Our Ref: EP/70/12/

17th September 2012

Alterations & first floor extension, providing a reduced garden room on the ground floor, together with conversion of garage to a gym & 2 new bedrooms, study & bathroom to first floor. Removal of existing pitched roof & replace with lower mono pitched roof
Sandgate House South Strand East Preston Littlehampton

1207 SK25 A
Sandgate House, East Preston
Elevations As Proposed - sheet 1
June 2012
scale: 1:100

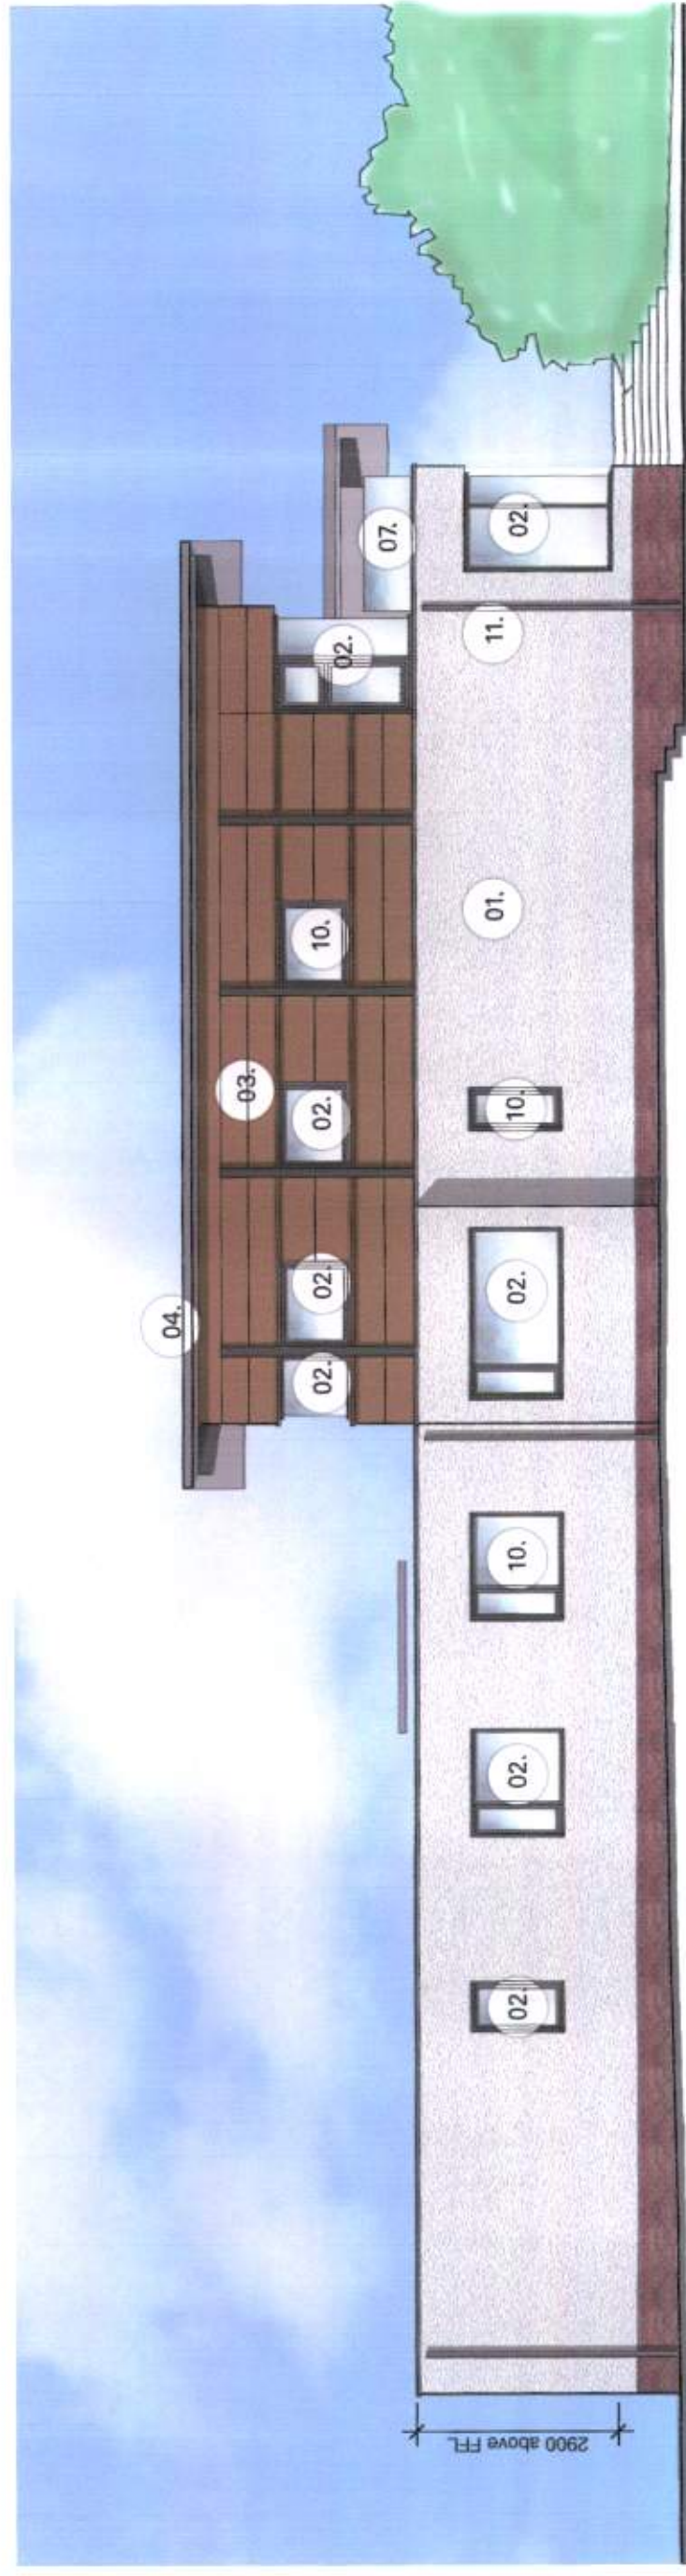
My main concern is that the proposed overall increase in height of the building on the west side of 1.7 metres (which will be even nearer to my home now that the highest point of the proposed roof has been altered to be on the east side of the west wing) will both decrease my afternoon sun, especially in the winter, and also reduce my privacy. □
The proposed new floor's windows and balcony on both its south and east side will reduce my seclusion and privacy as the occupants will be able to see into my garden, ground floor glass bay and also into my west side windows. □
My view will also be effected looking westwards from my first floor west windows where the added floor is proposed. □
On the east side of the house the proposed flat roof will only be 40 cm lower than the existing top of the pitched roof. The increase of the east elevation vertical wall height from 3.4 metres to 4.2 metres will increase the overall bulk. □
